Your Ref: OWPC24930
Our Ref: WA/105/19/CLE 14-11-2019
Please ask for:
Andrew Wood

Lawful development certificate for an existing use - confirmation an existing hip to gable roof extension & rear dormer is permitted development

Missione Vecchia Arundel Road Fontwell

ELEVATIONS
1:100

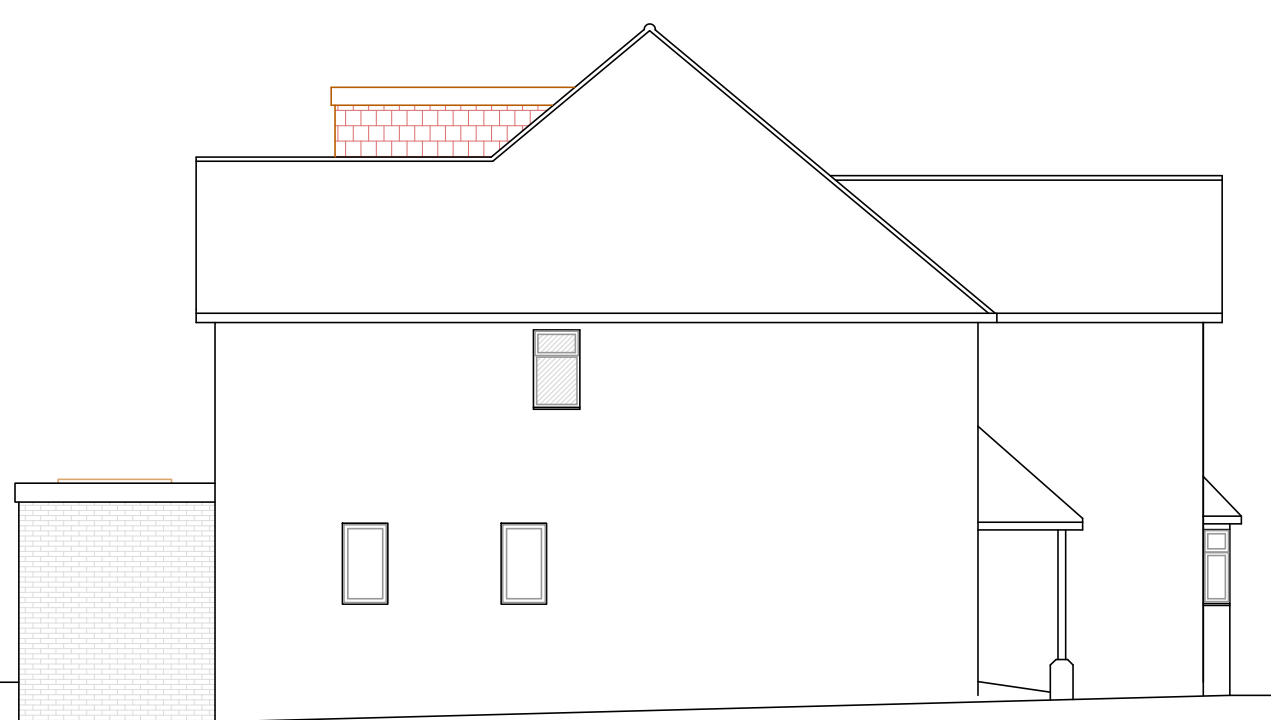
I don't have a problem with the dormer window, but the back extension has a large window, which will effect my privacy in my garden and several other neighbours, also they will be able to look directly up into my bedroom and other peoples also.
